CITY OF ALBUQUERQUE

June 11, 2015

Re: Andalusia Villas
5300 Antequera NW Buildings 7, 8 & 10
Request Permanent C.O. – Not Accepted
Engineer's Stamp dated: 1-18-14 (E12D15C)
Certification dated: 6-8-15

C2.03

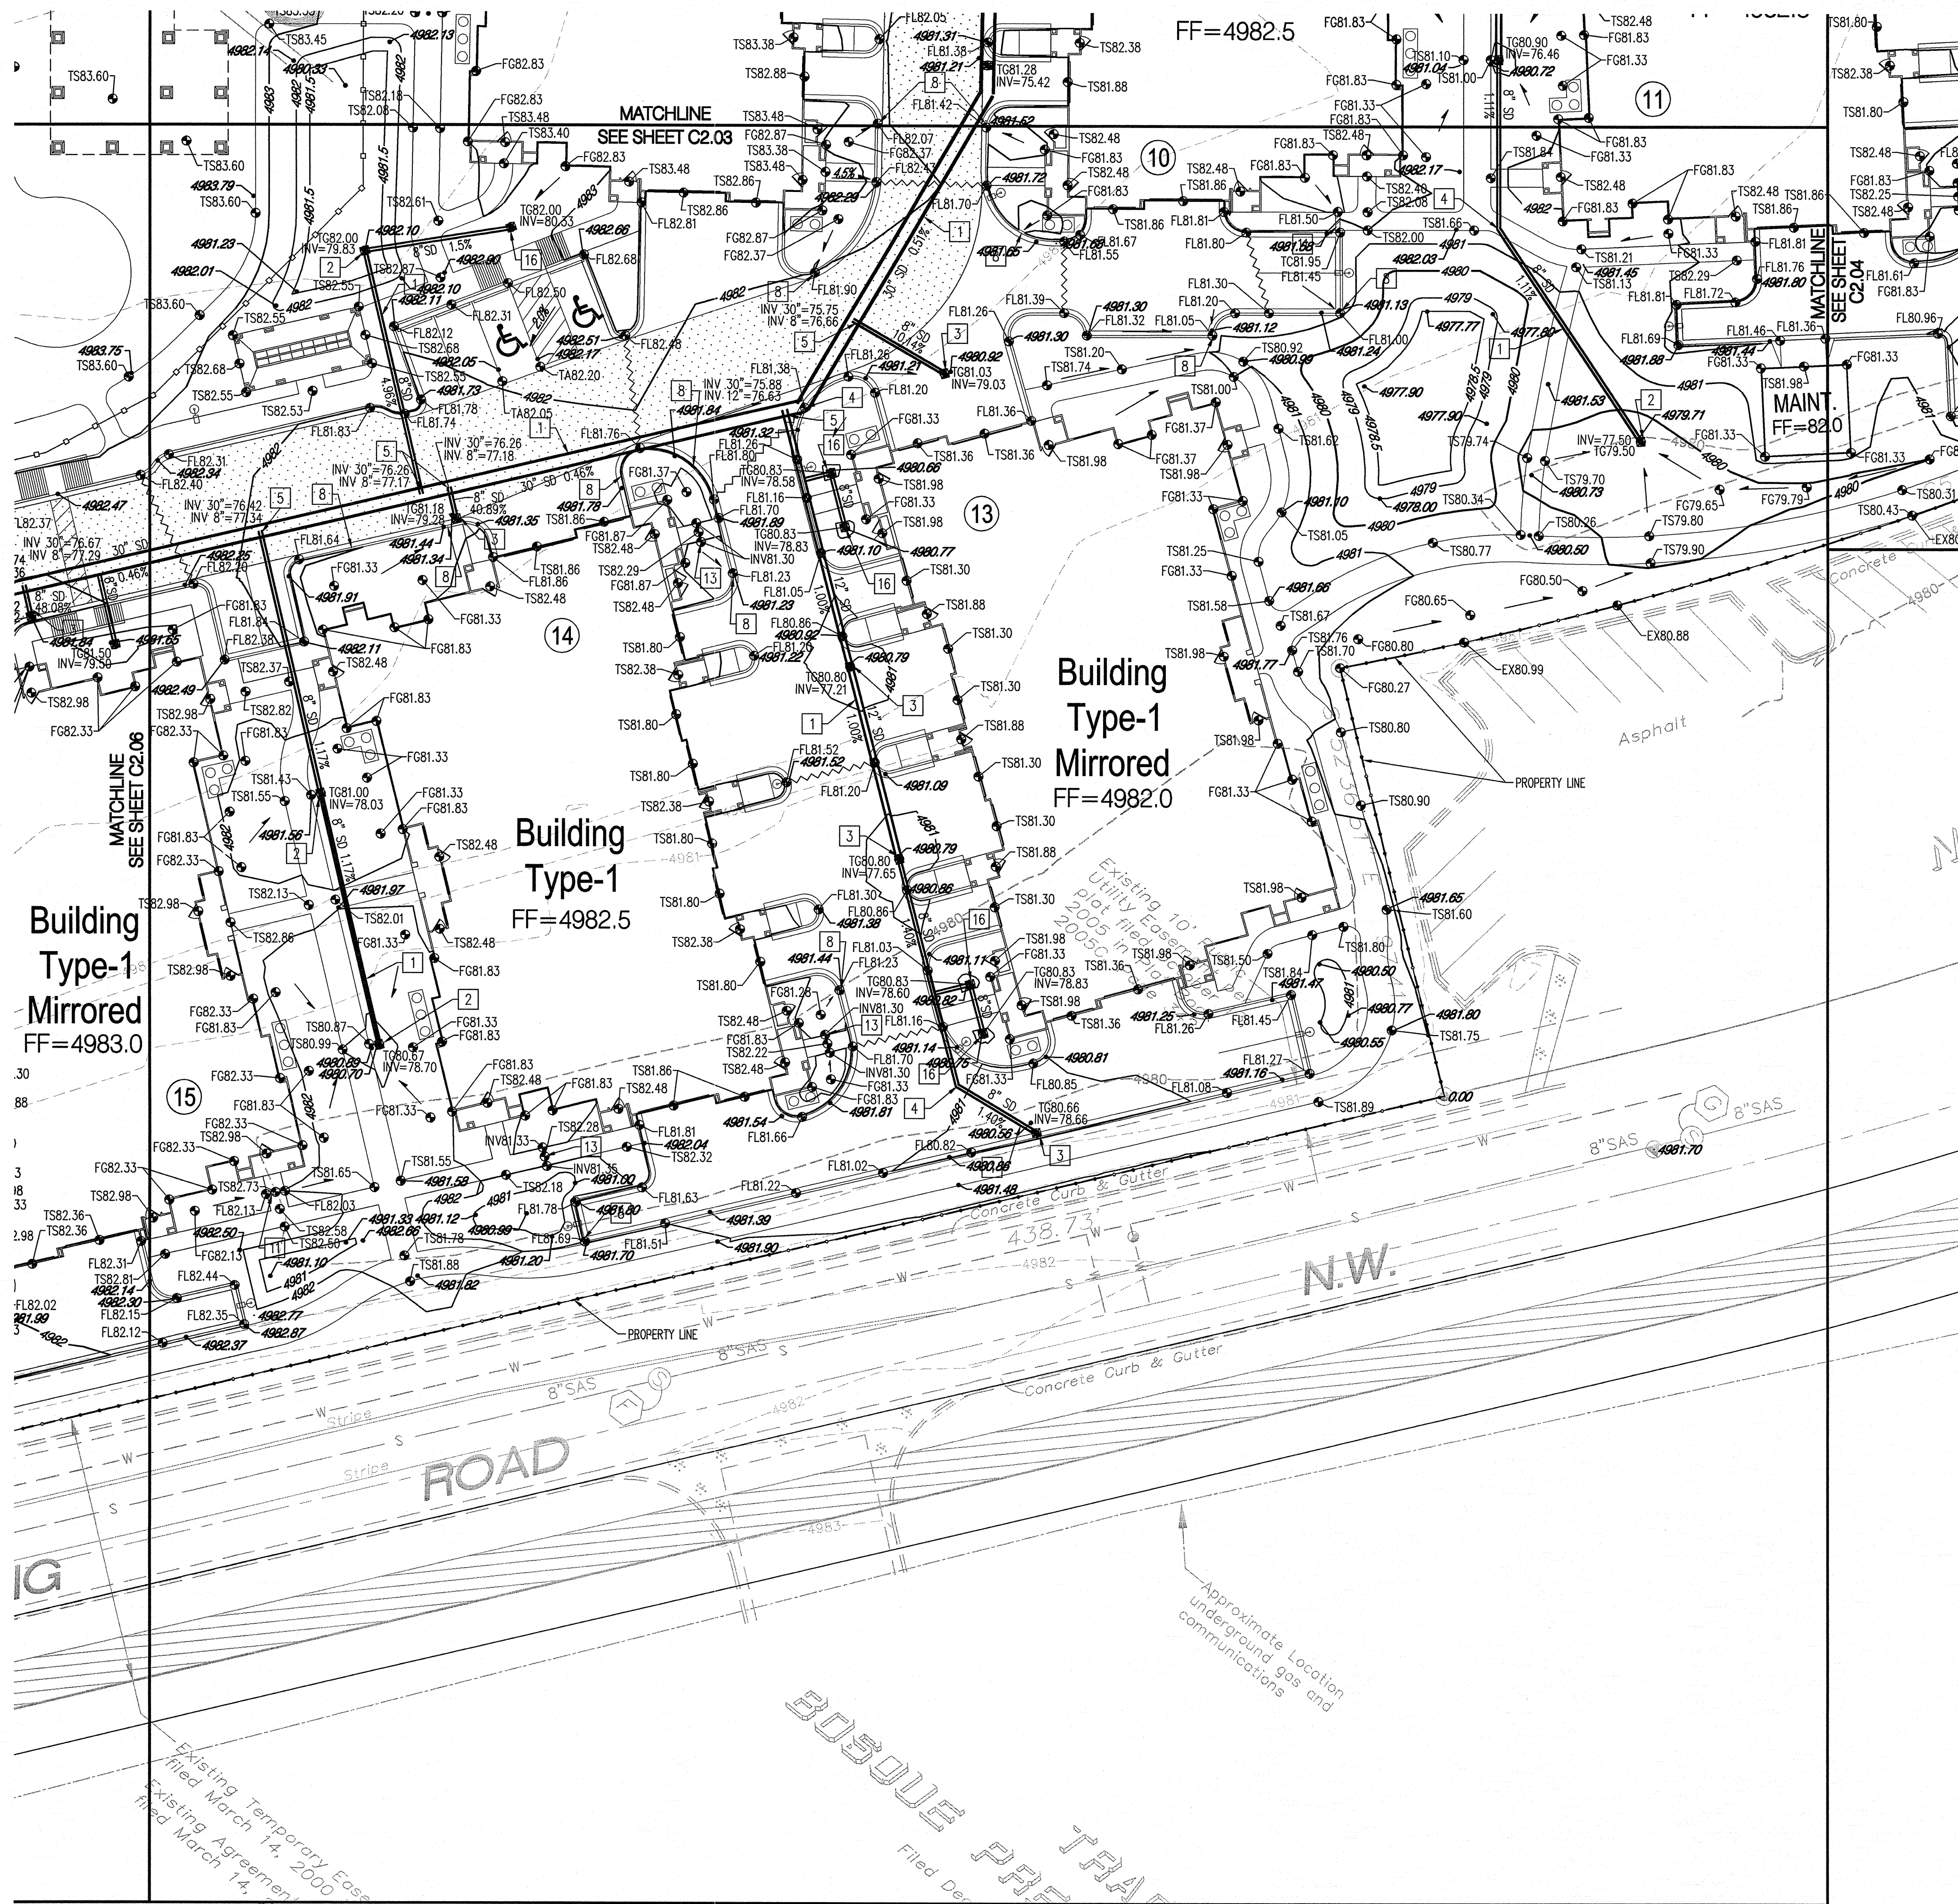
Based on the Certification received 6/10/2015, the site cannot be accepted for release of Certificate of Occupancy by Hydrology until the following comments are addressed.

- Three (3) inlets are missing.
- A manhole was relocated, need new inverts and reason why the relocation. How is maintenance going to be performed in the three way intersection of the storm sewer?
